# LSC RESPONSES TO TIS REDLINE COMMENTS

Overlook at Homestead (LSC #S234200)

Figure 5
**Estimated Buildout
 Site-Generated Traffic**

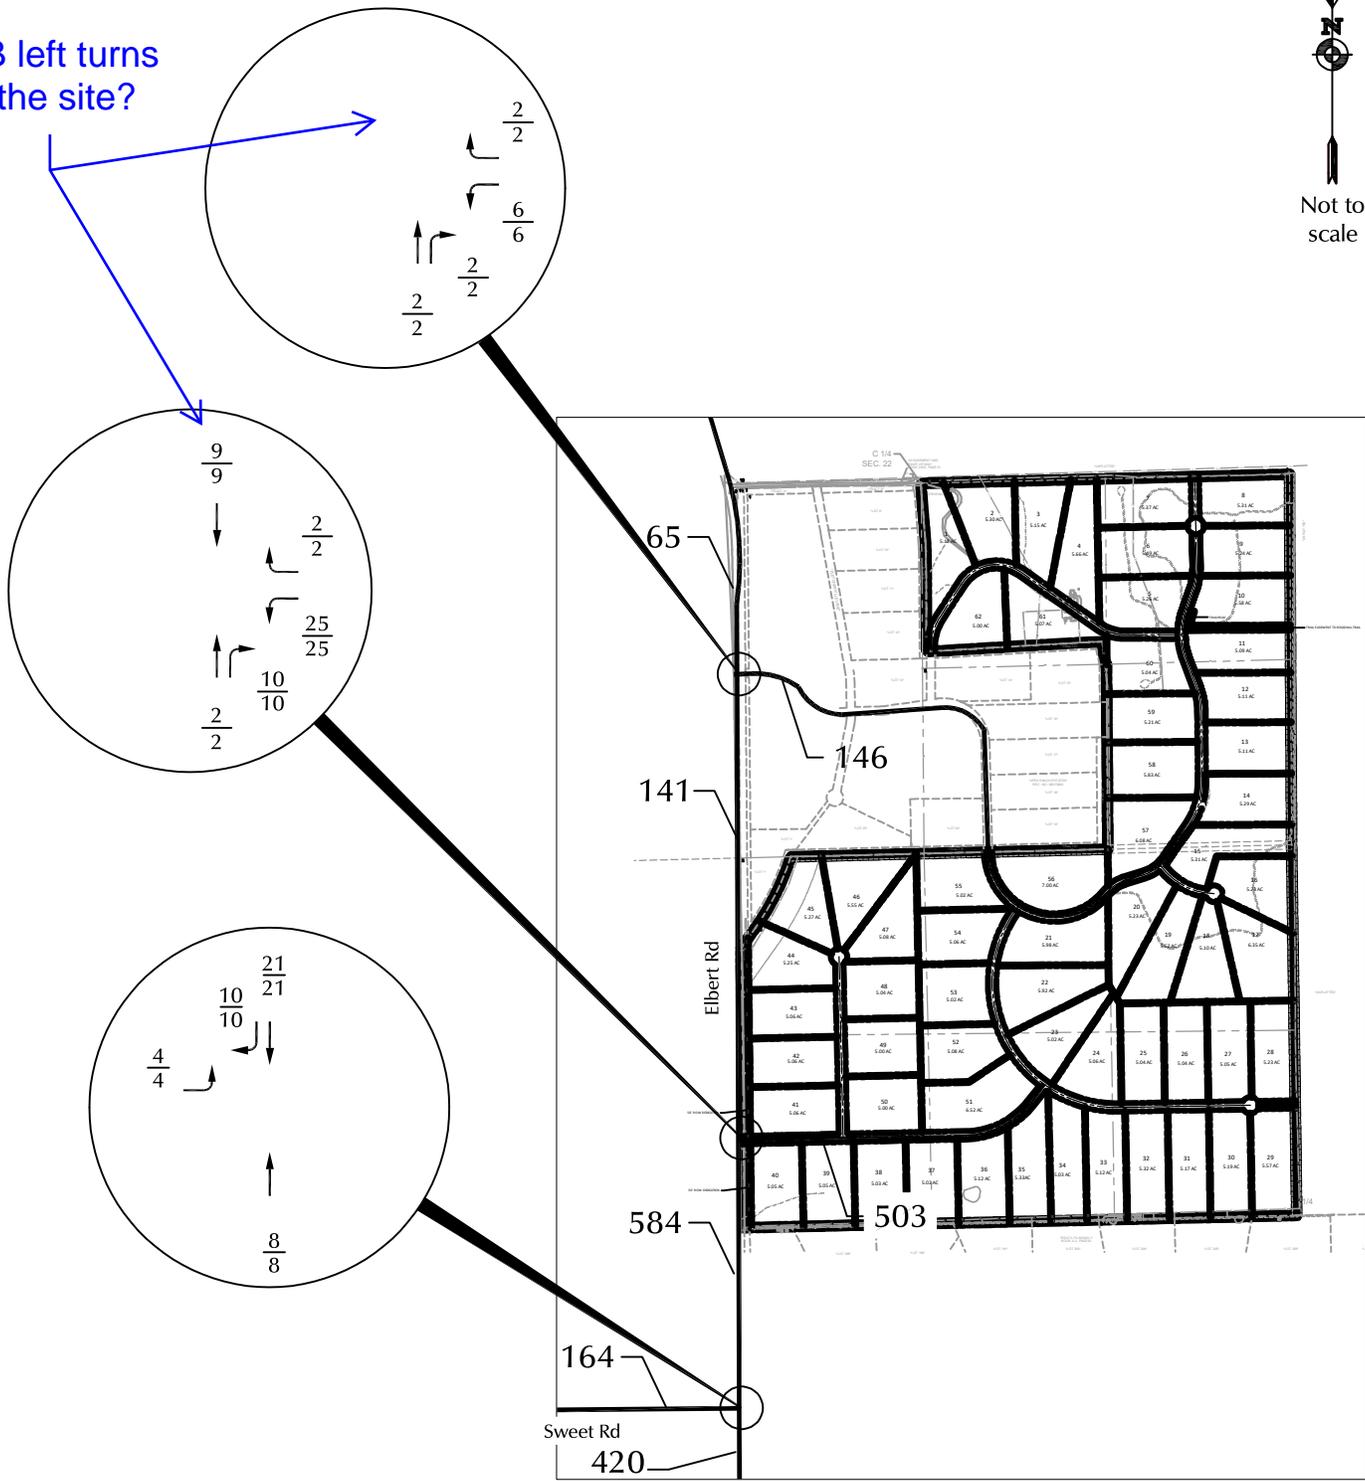
0 SB left turns into the site?

LSC Response: The figures (and corresponding level of service printouts) have been updated/corrected.

# Sight Distance Exhibits 1 & 2

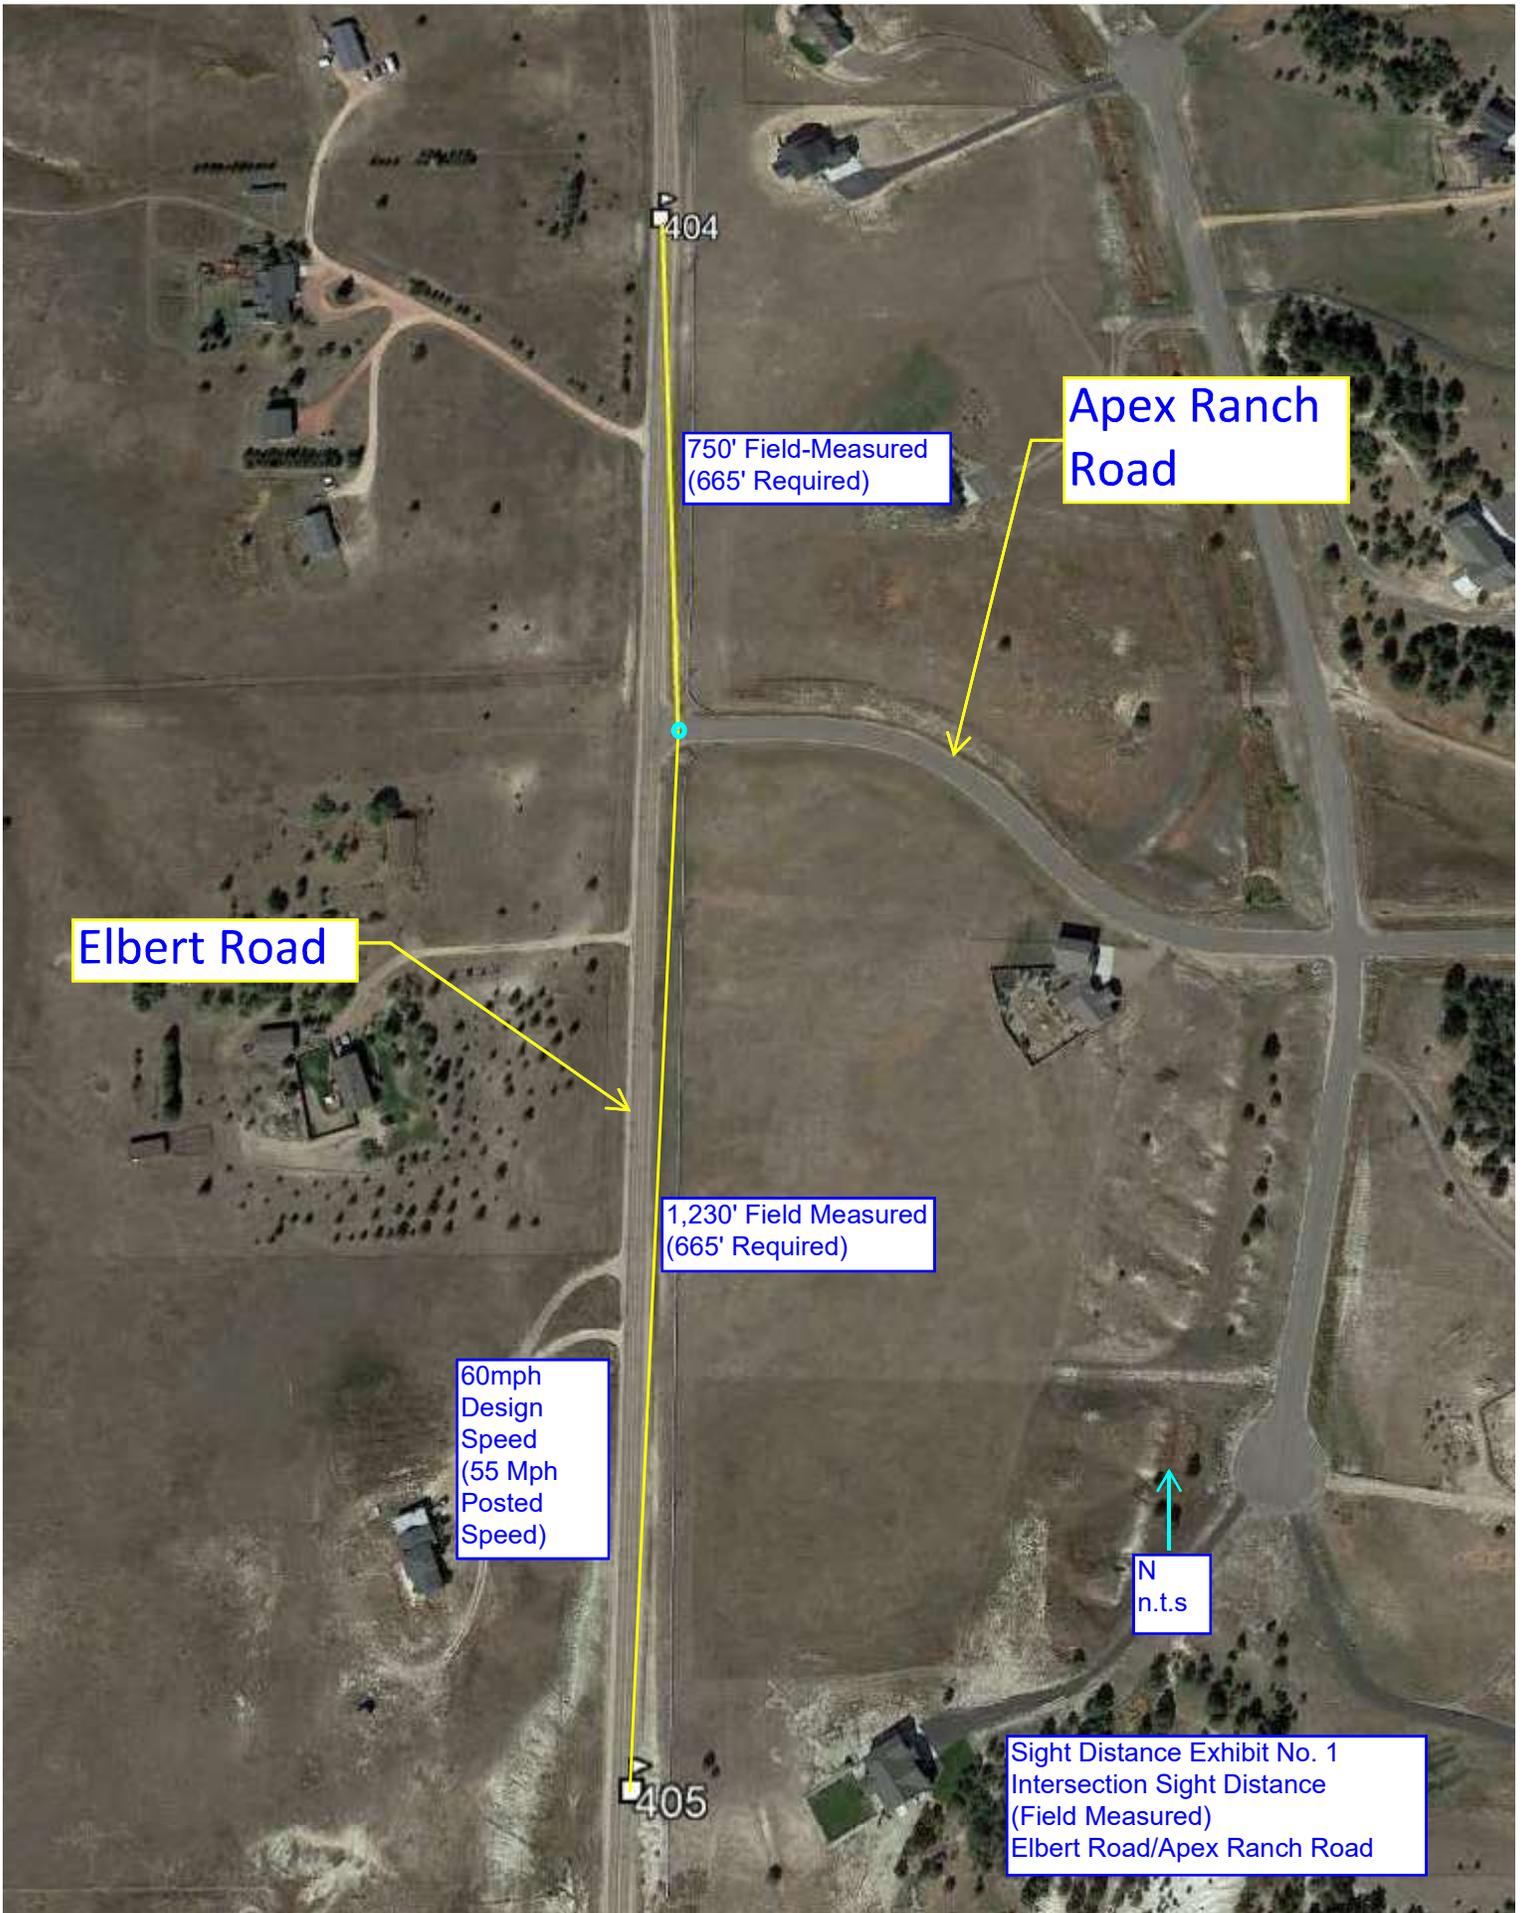
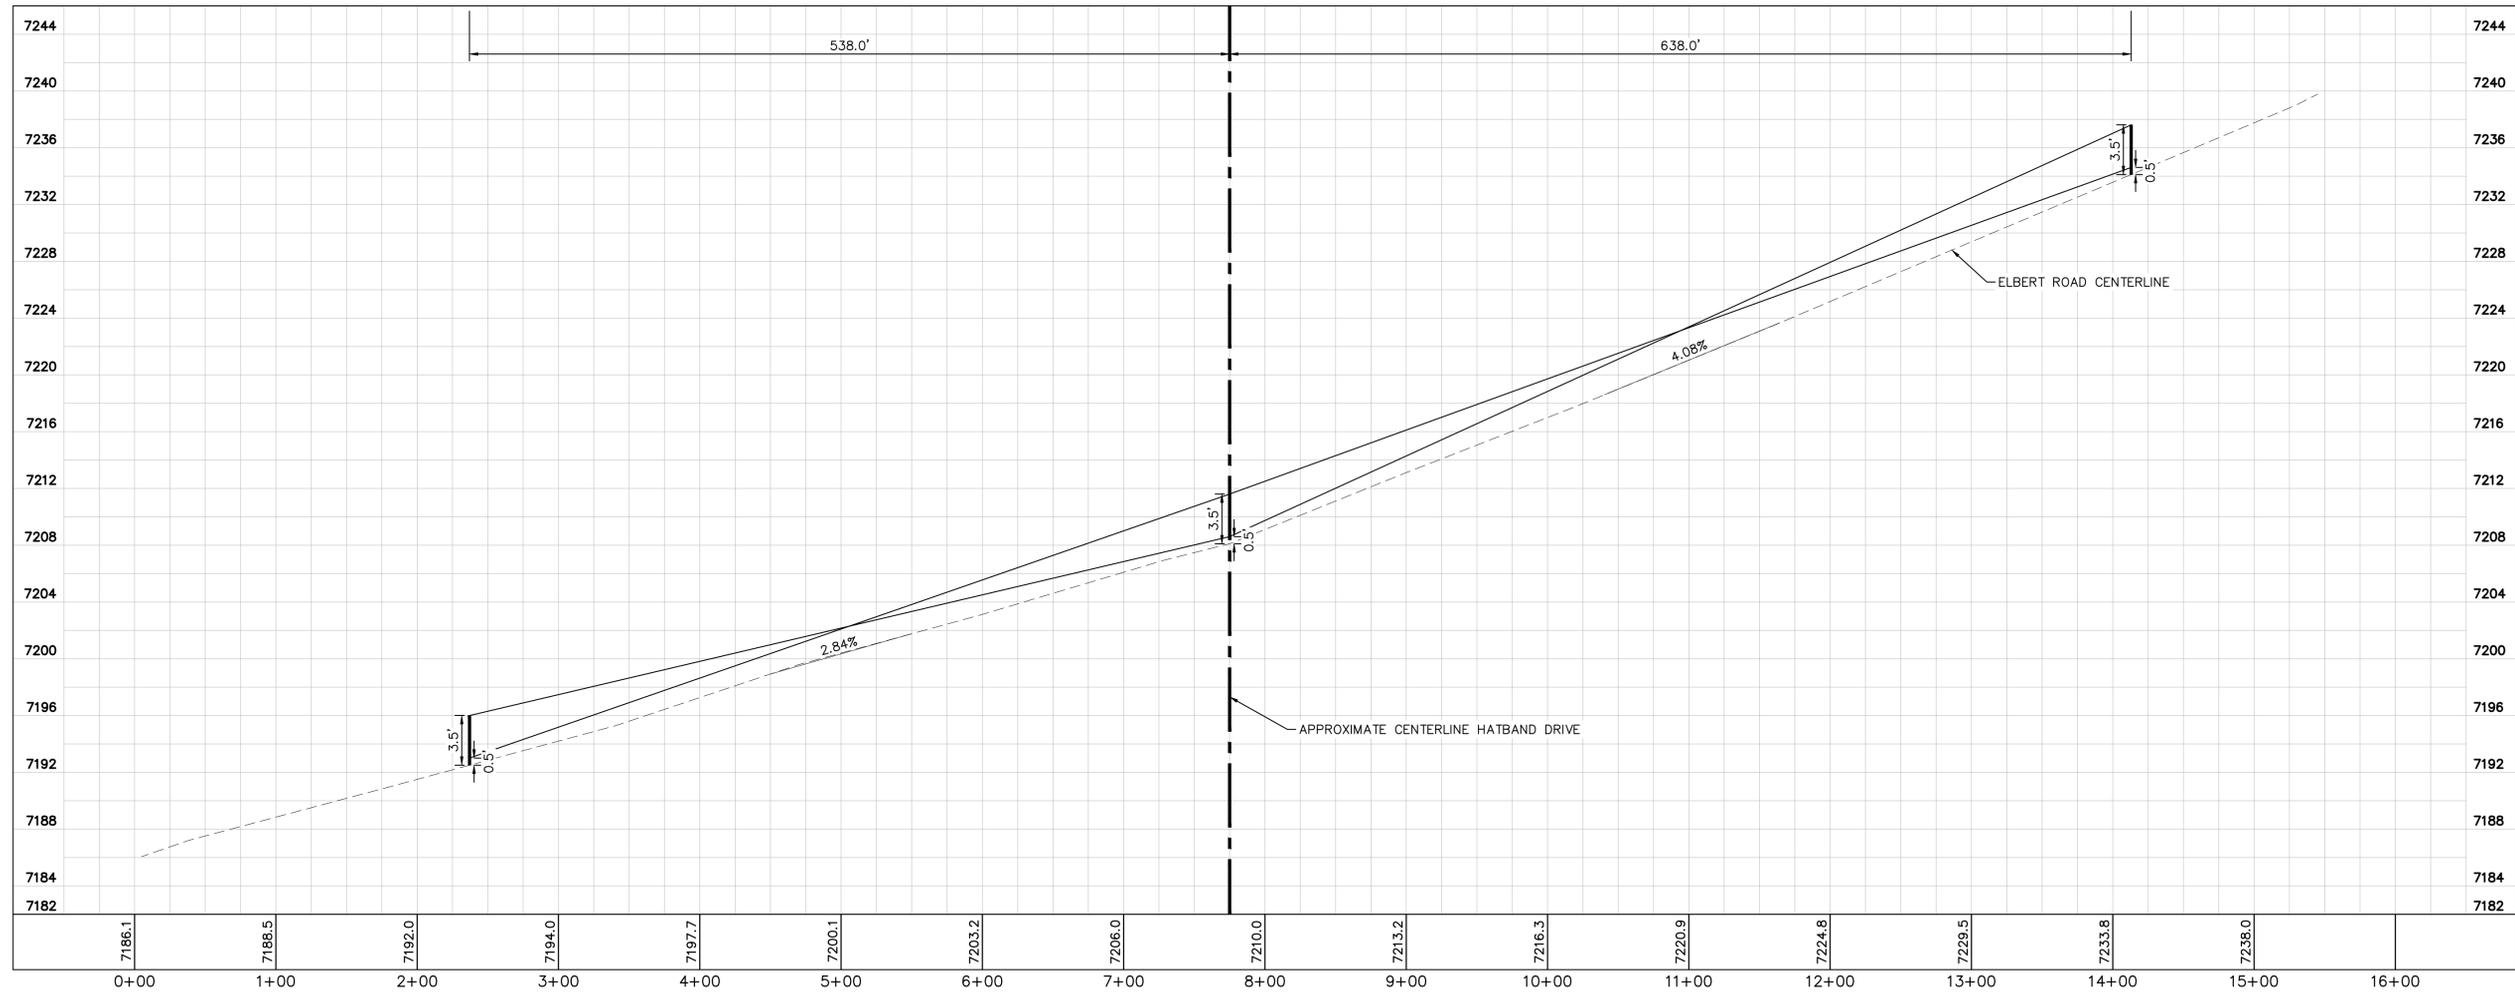
Summarize line of sight finding for existing and all proposed entrances/intersections Provide line of sight exhibits.  
(missing)

LSC Response: The sight distance findings have been added to the "INTERSECTION SIGHT DISTANCE" section of the report. Exhibits have been provided. A bullet has been added to this concluding section stating that ECM sight distance would be met along with a reference back to the sight distance section.
